From: [Paul Christmas](#)
To: [Necola Chisholm](#)
Cc: [Nayeem Islam](#)
Subject: Planning & Environment 26/05/2015 MP08_0046 MOD 1 d" Albora Marina - The Spit - submission of a Section 75W modification application
Date: Tuesday, 9 June 2015 4:35:48 PM
Attachments: [Planning & Environment 26 05 2015 MP08_0046 MOD 1 d Albora Marina - The Spit - submission of a Section 75W modification application.PDF](#)

Dear Necola, Manly Council has reviewed the attached s75W modification application and while not raising an objection, it is requested that the Department include consideration in their assessment of the proposed amendments of the following couple of matters.

MPO80046 MODIFIED PLAN DA01/W

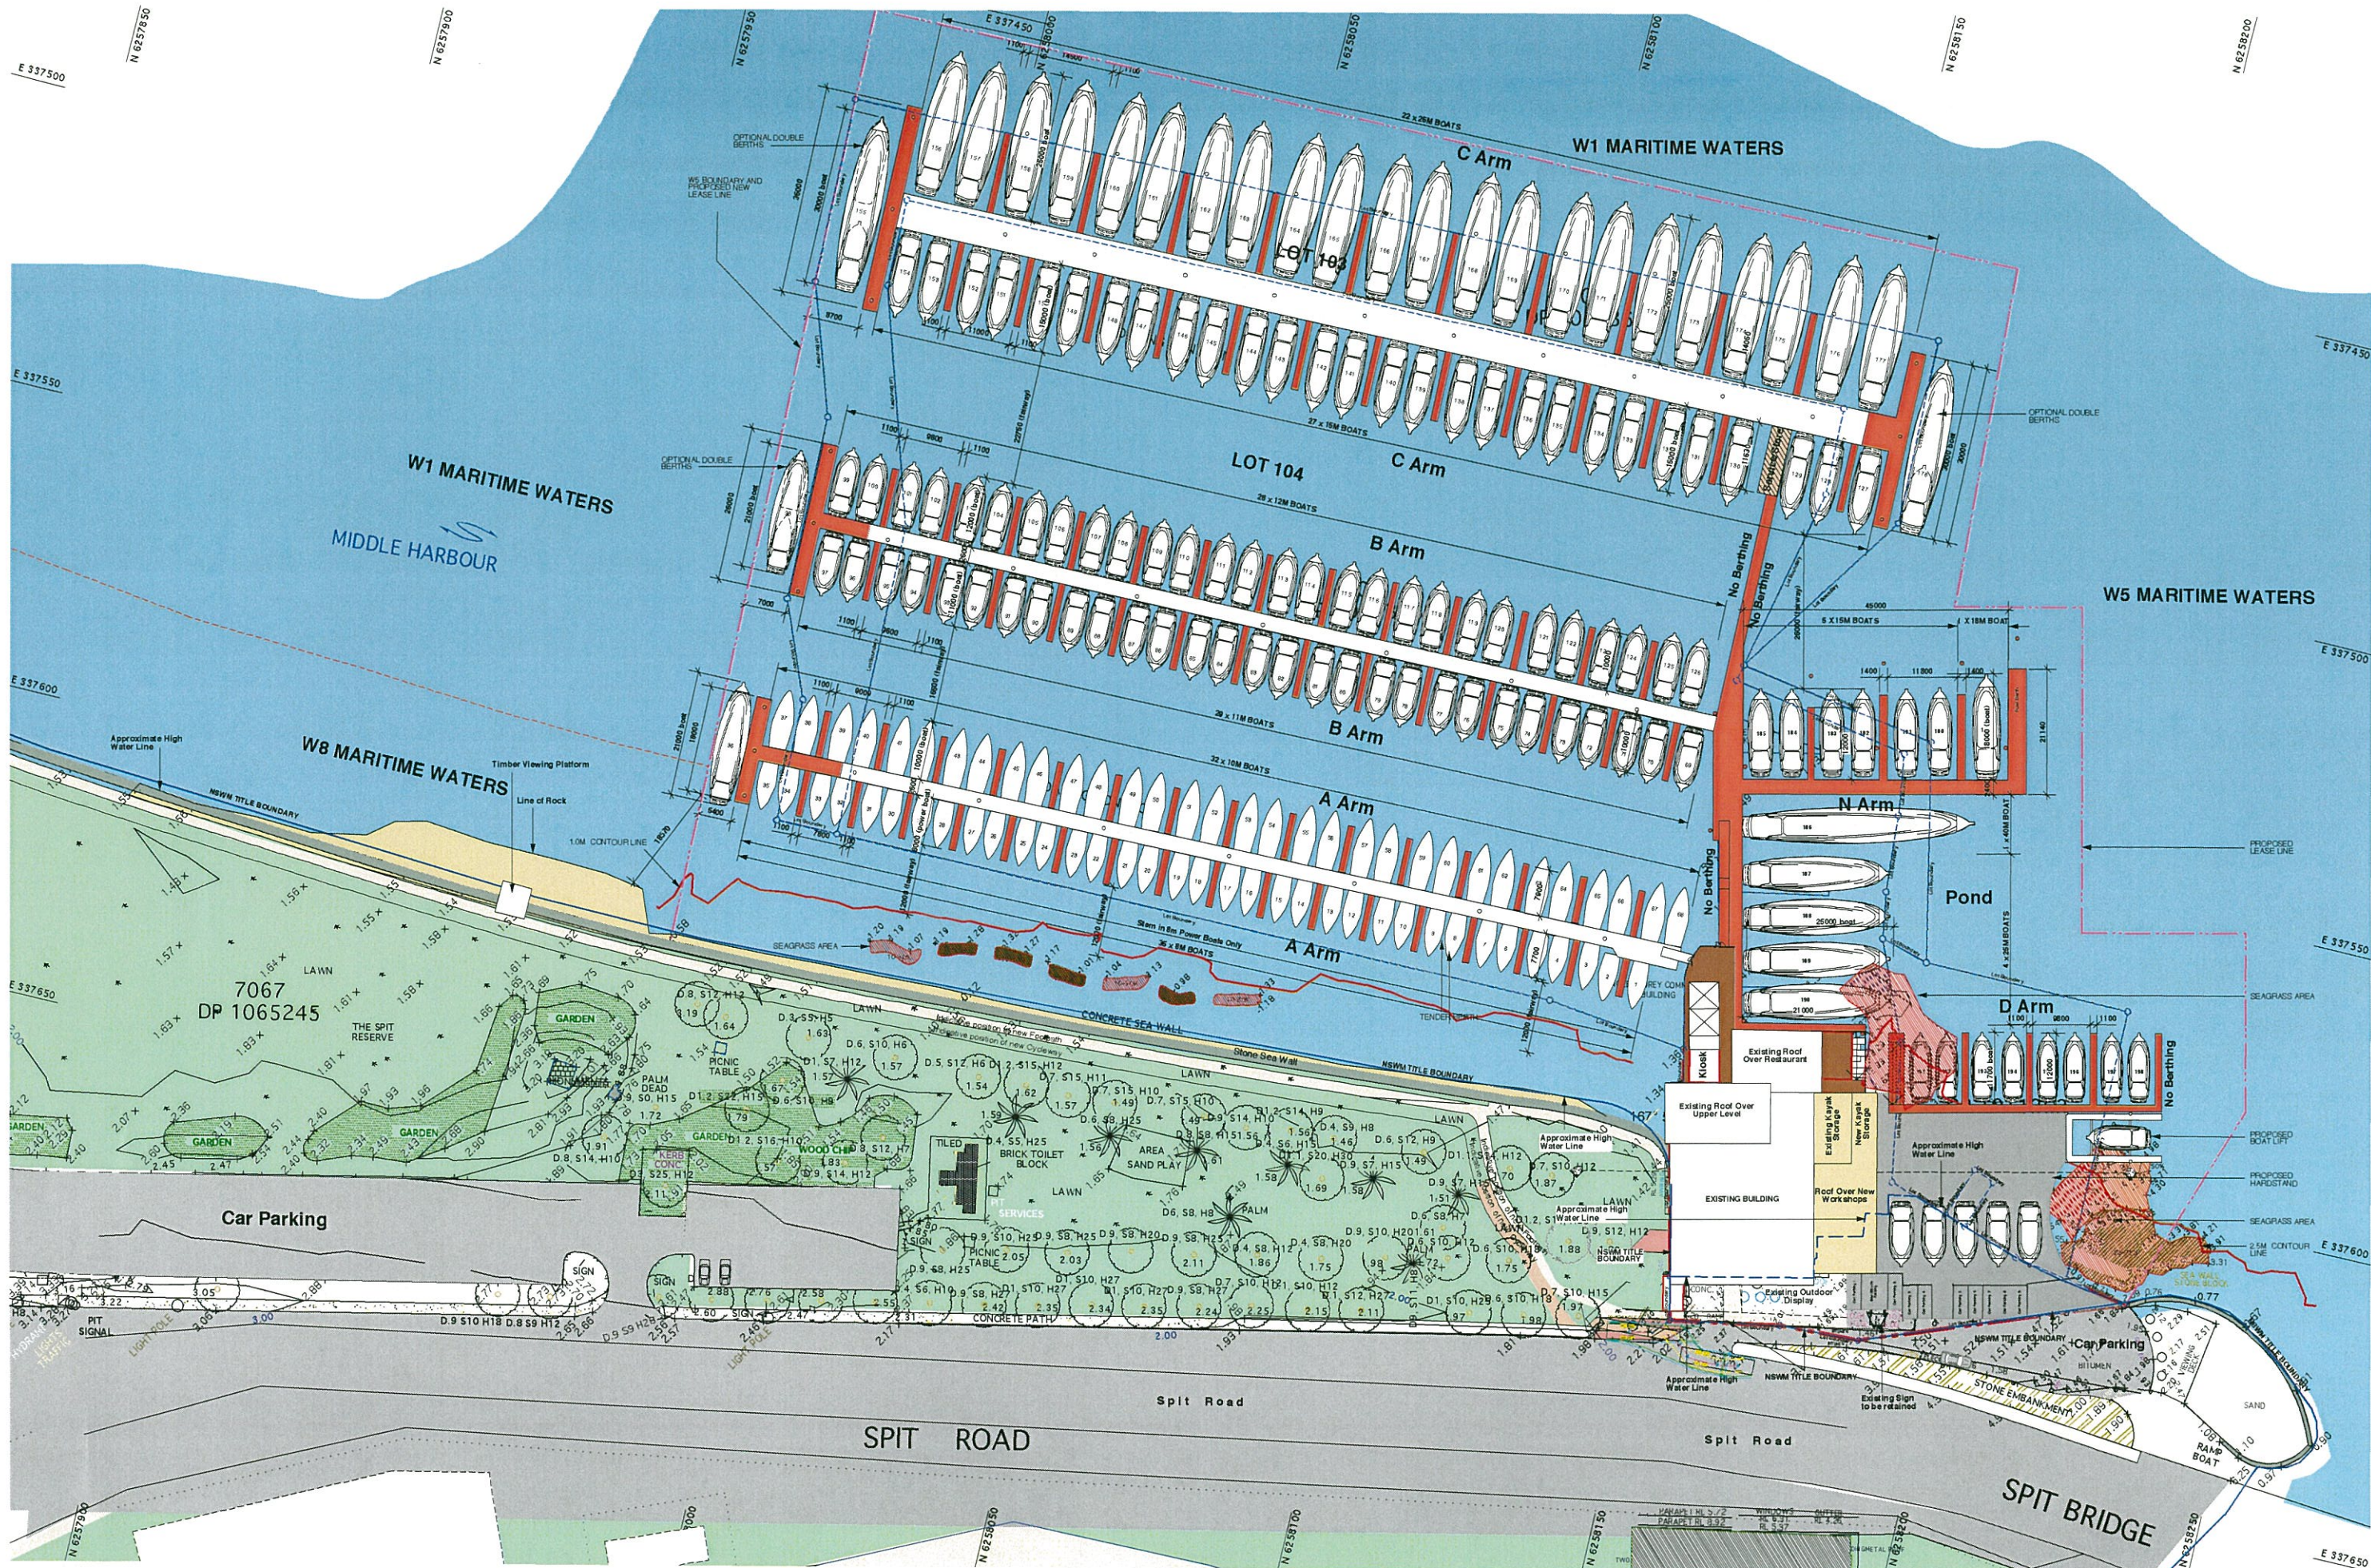
In relation to the proposed relocation of the fuel wharf, please consider the ongoing retention of fuel and sewerage systems for public as well as private use as originally approved.

In relation to a minor rearrangement proposed for the 9 onsite parking spaces, please consider that there is strictly no loss in the level of vehicular access to be provided for both onsite and public spaces including an indented manoeuvring bay to improve egress to parking as well as access for garbage and trucks.
